**WestConnex M4-M5 Link project (SSI 16\_7485)**

Thank you for the opportunity to comment on the Environmental Impact Statement (EIS) for the WestConnex M4-M5 Link project (SSI 16\_7485). NSW Health makes the following submission for your consideration.

## Detailed comments from NSW Health's review of the environmental impact statement for the WestConnex M4-M5 Link project (SSI 16\_7485)

Figure 5-48 Campbell Road motorway operations complex (MOC5)

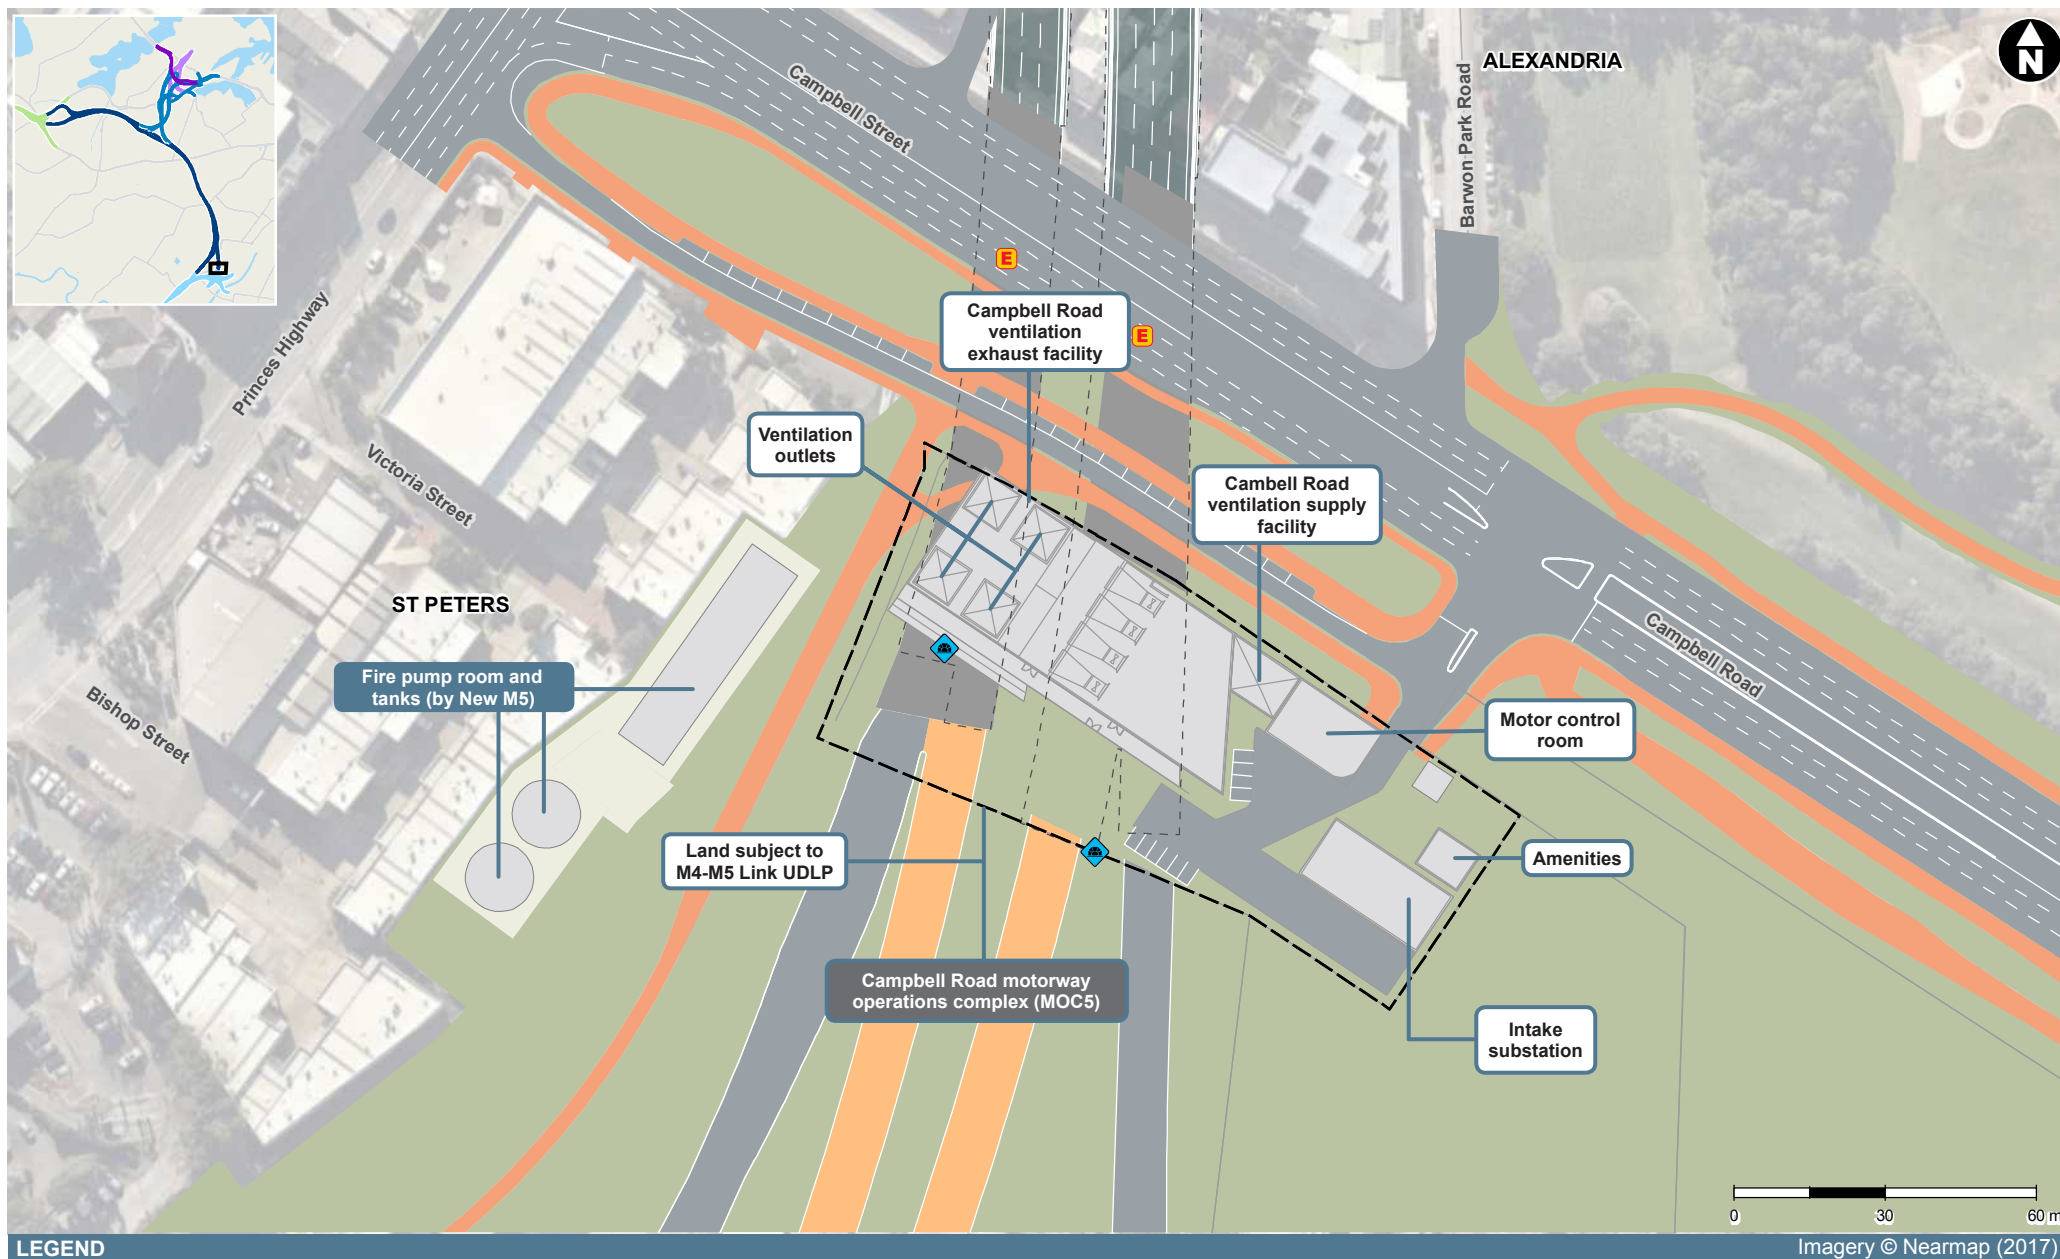
The HHRA identified unacceptable health risks associated with air pollution 30 metres above ground-level adjacent to the tunnel ventilation stack at the St Peters interchange. This is a hypothetical risk because current buildings are less than 10 metres in height at that location. Consideration should be given to ensuring that planning controls are put in place so that building heights in the area are limited and exposure to these levels of PM<sub>2.5</sub> are avoided.

The EIS determined that air quality at an elevation of 10 metres near the proposed St Peters interchange, which includes a 20 metre high ventilation stack, would be minimally impacted by the project. Air quality at heights between 10 and 30 metres were not modelled. Therefore the impact of the project on air quality at heights between 10 and 30 metres is unknown. On this basis, planning controls should be developed in the vicinity of the St Peters interchange to limit future building heights to no higher than 10 metres.

There is inconsistency within the EIS with regards to developing planning controls for the St Peters area. The air quality assessment states that planning controls in the vicinity of St Peters should 'ensure future developments at heights 30 metres or higher are not adversely impacted by the ventilation outlets' (page 9-106), while the HHRA states that planning controls should 'ensure future developments at heights above 10 metres are not adversely impacted by the ventilation outlets' (page 11-34). Unless air quality assessment of St Peters demonstrates acceptable impacts on air quality at heights between 10 and 30 metres, planning controls should limit building heights in that area to 10 metres.
